From: Jones, Kate
Sent: 15 March 2023 19:18
To: Plan Apps
Subject: FW: application 2022/0967/FUL

Please could the email below be indexed as a public comment from 'New Ormskirk Residents Group' in relation to the above planning application.

Application 2022/0967/FUL. Former indoor market, change of use to mixed leisure and retail,

FIRST FLOOR PLAN

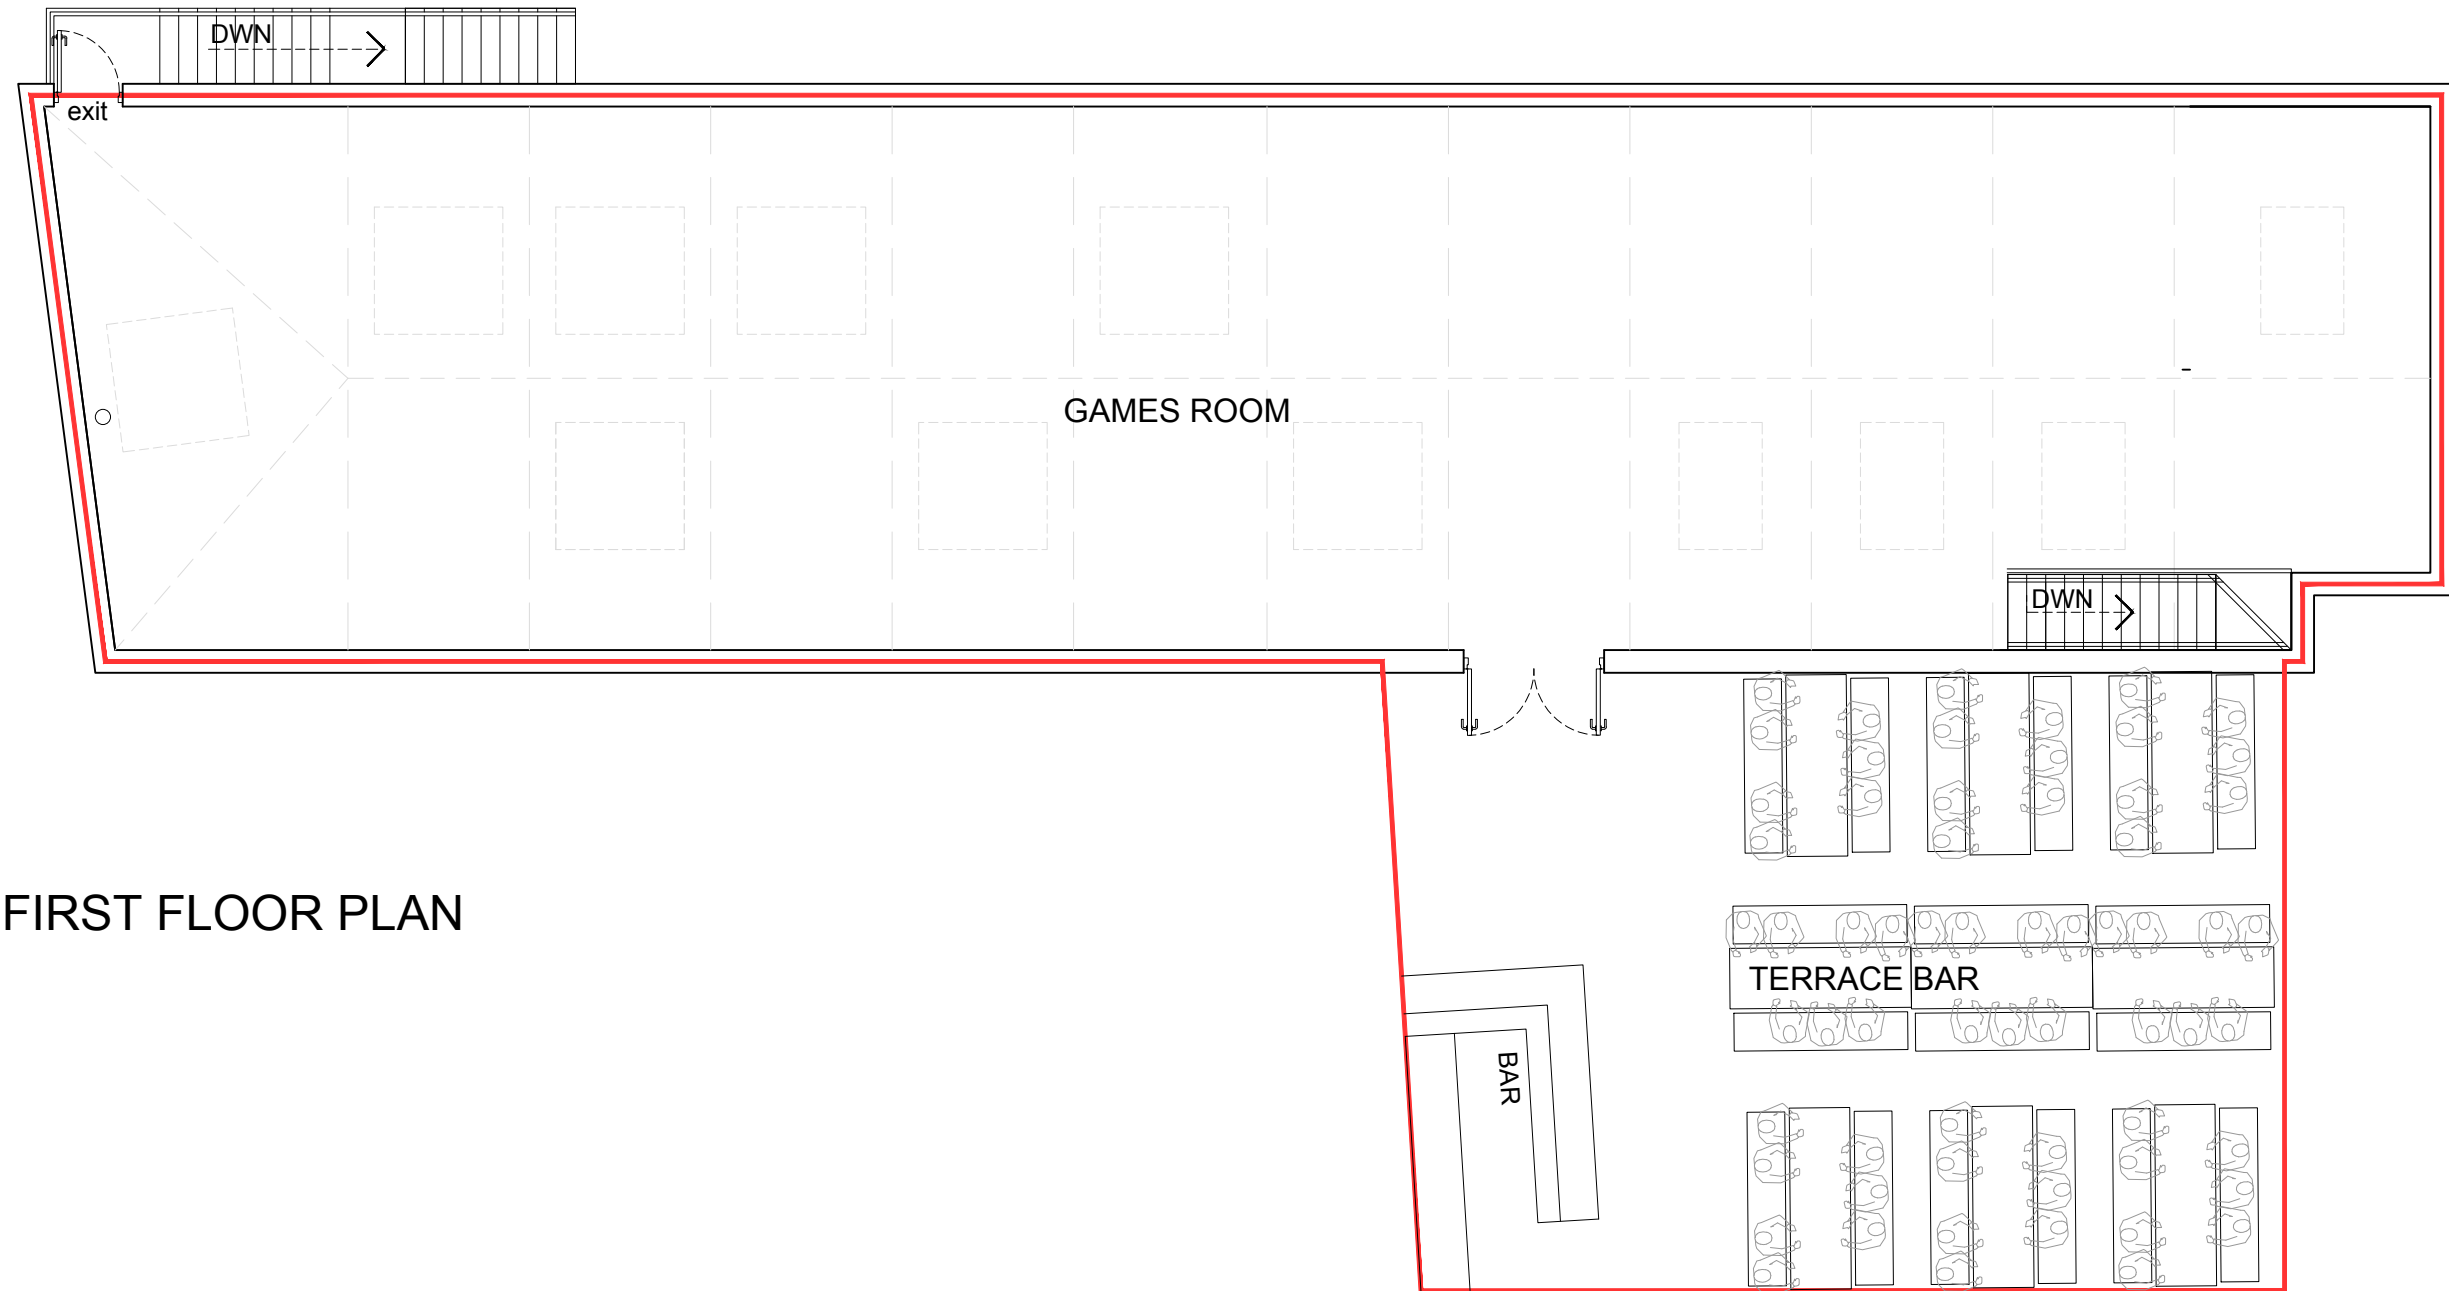
- The ground floor appears to be very overcrowded with kitchens, eating and drinking seating and tables and a bar. No windows at all are indicated and just one entrance and three exits marked. We do not see any comment by the Fire Service.
- The first floor shows a large area just market Games Area –surely there needs to be considerable detail here on what it is envisaged to be taking place in this area as licences may be required.
- The Terrace Bar potentially presents a problem with noise which could carry to and disturb nearby residential areas.
- We note no toilets marked on the first floor and terrace bar areas, neither are any external fire escapes shown.
- There is no parking marked and little detail about security.
